REPORT UPDATE

Application No: BR/208/14/PL

LOCATION: Land adj to 65B Gravits Lane
Bognor Regis

PROPOSAL: Construction of 1No. 2 bedroom chalet bungalow

LOCATION PLAN
NO. ADJACENT TO 65B GRAVITS LANE BOGNOR

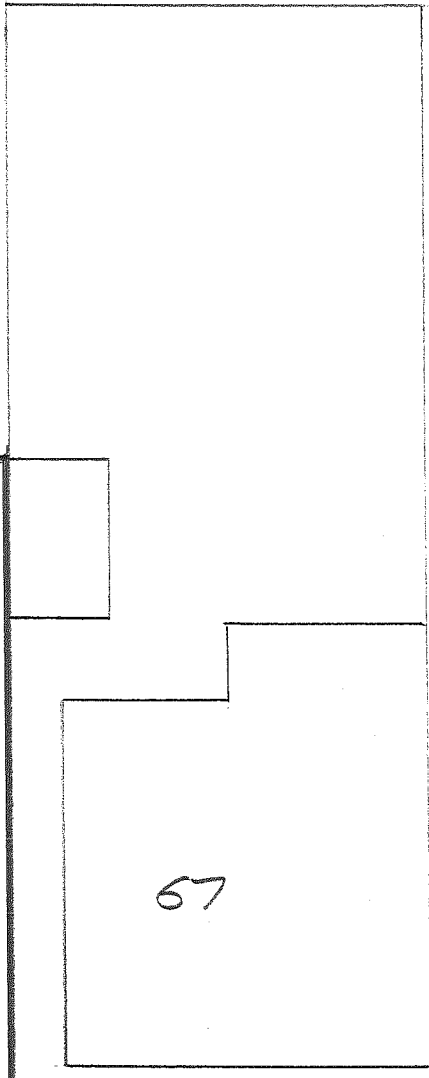
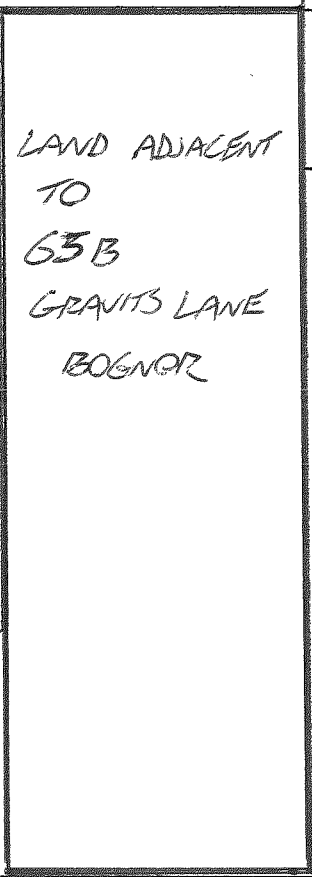
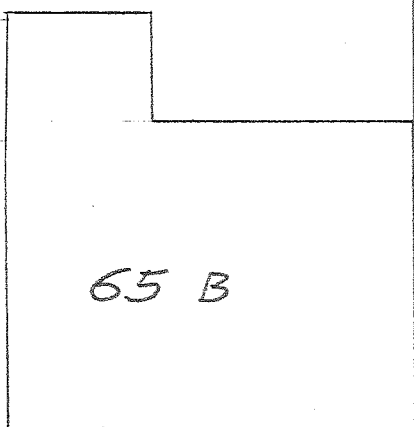
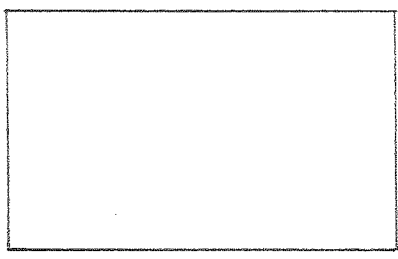
* The original block plan was some 18m² short of the required 85m² standard but an amended plan has been received which takes a small area of land from 65B and increases the private amenity space to just over 85m². The garden is only 8.4m deep but this is the depth of the existing garden and given that the area standard is met, it is considered that the proposal is compliant with Policy D DM3. It is considered that this change also maintains an appropriate amount of private amenity space to 65B.

- 10 INFORMATIVE: For the avoidance of doubt, Plan no. 2 "Proposed Site and Roof Plan (Second Revision ~ 20/10/14)" shows the site area (applicant red edge) as opposed to the Plan No. 1 - Block/Location Plan which was originally submitted.

REVISED PROPOSED PLANS AND ELEVATIONS
FOR LAND ADJACENT TO 65B GRAVITS LANE

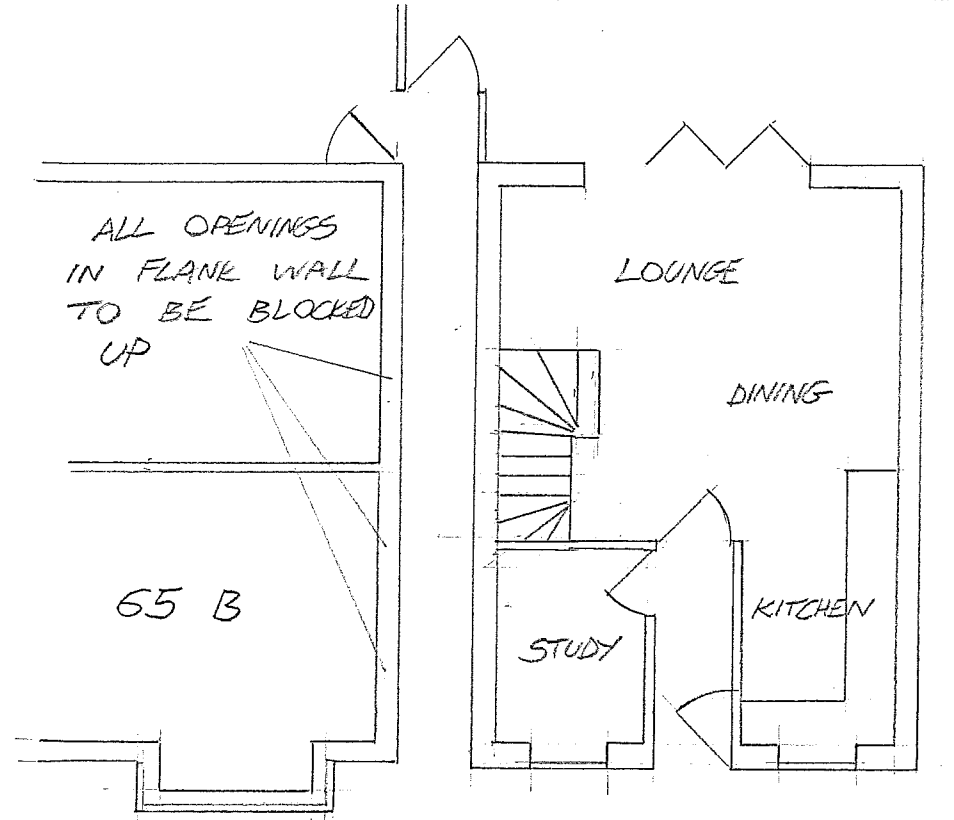
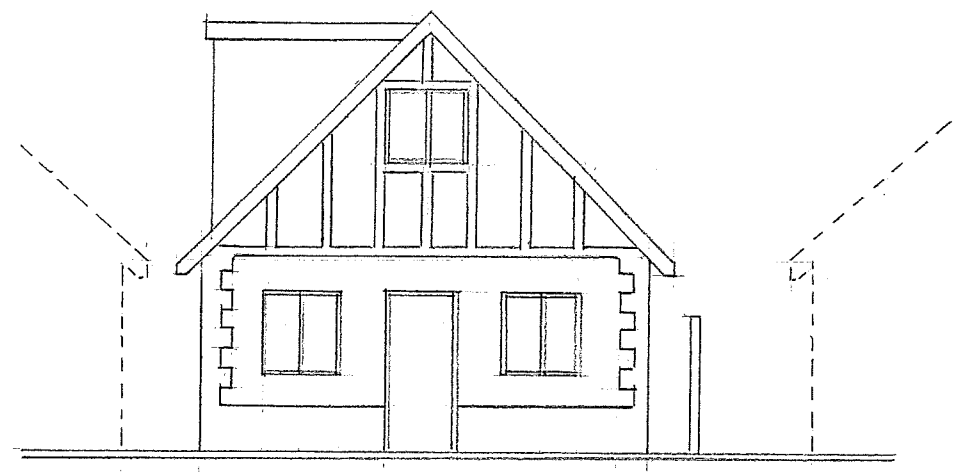
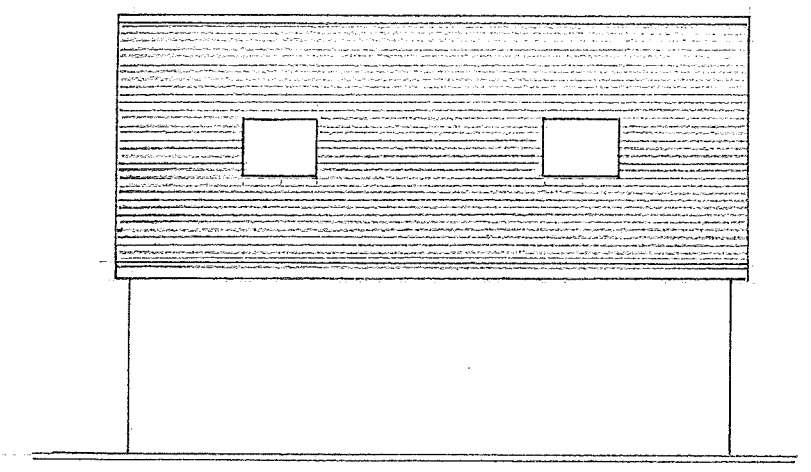
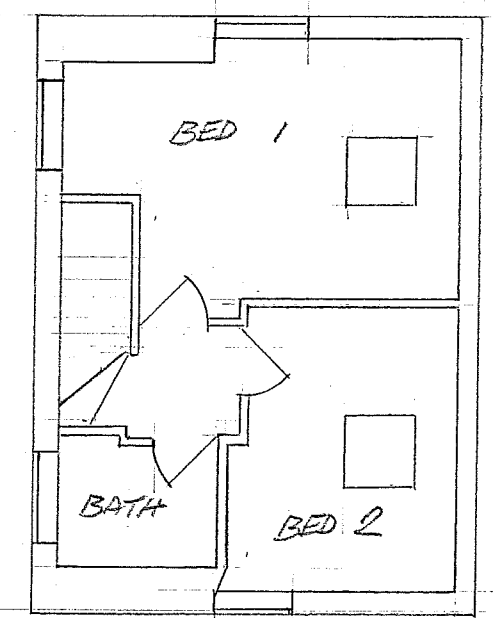
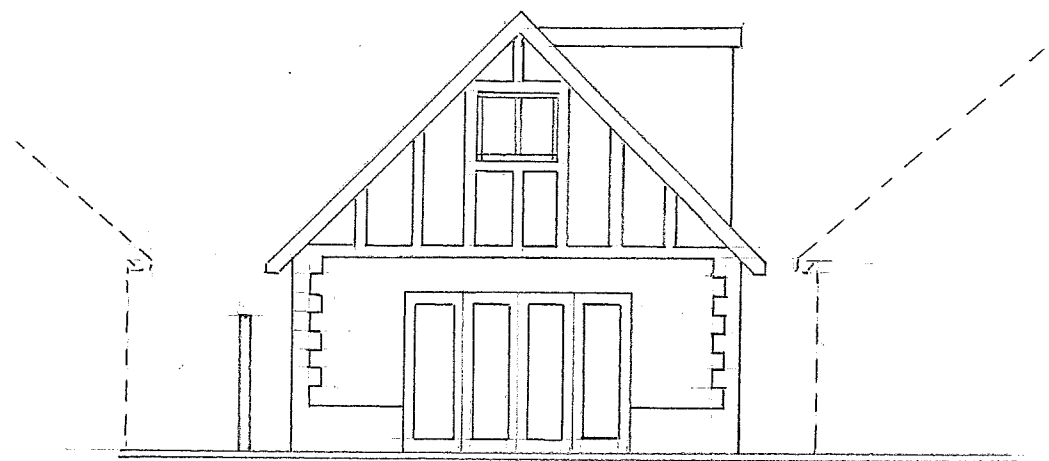
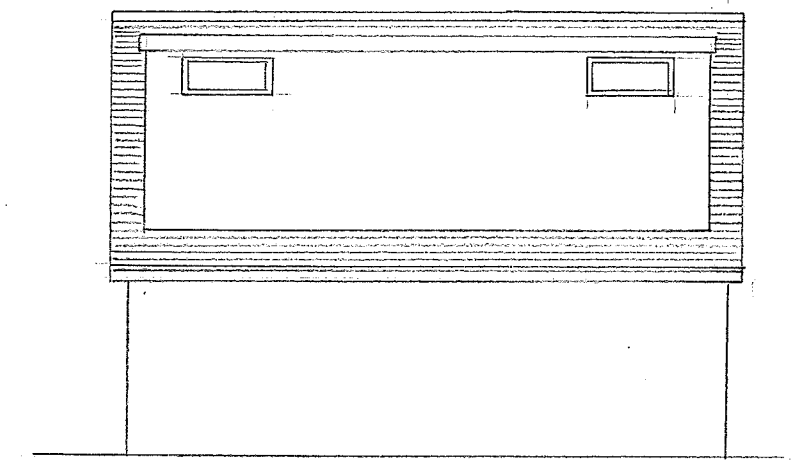
- * The new scheme includes a side dormer facing 65B with 2 high level windows;
- * The new scheme includes two velux rooflights on the north eastern roof plane;
- * The new scheme adds a bathroom to the first floor; and
- * The new scheme increases the size of the rear garden by approximately 21m².

There are no proposed ground floor flank windows which might invade the privacy of 67's existing ground floor windows. There are first floor velux windows in the north eastern roof slope but these are secondary windows and it is therefore acceptable to require them to be obscure glazed and non opening. This will protect the privacy of the neighbouring property. There would

- 5 The high level first floor bathroom window on the southwest elevation of the building shall at all times be glazed with obscured glass.

- 6 The two rooflights/velux windows in the north eastern roof plane of the building shall at all times be glazed with obscured glass and permanently fixed to be non-opening.
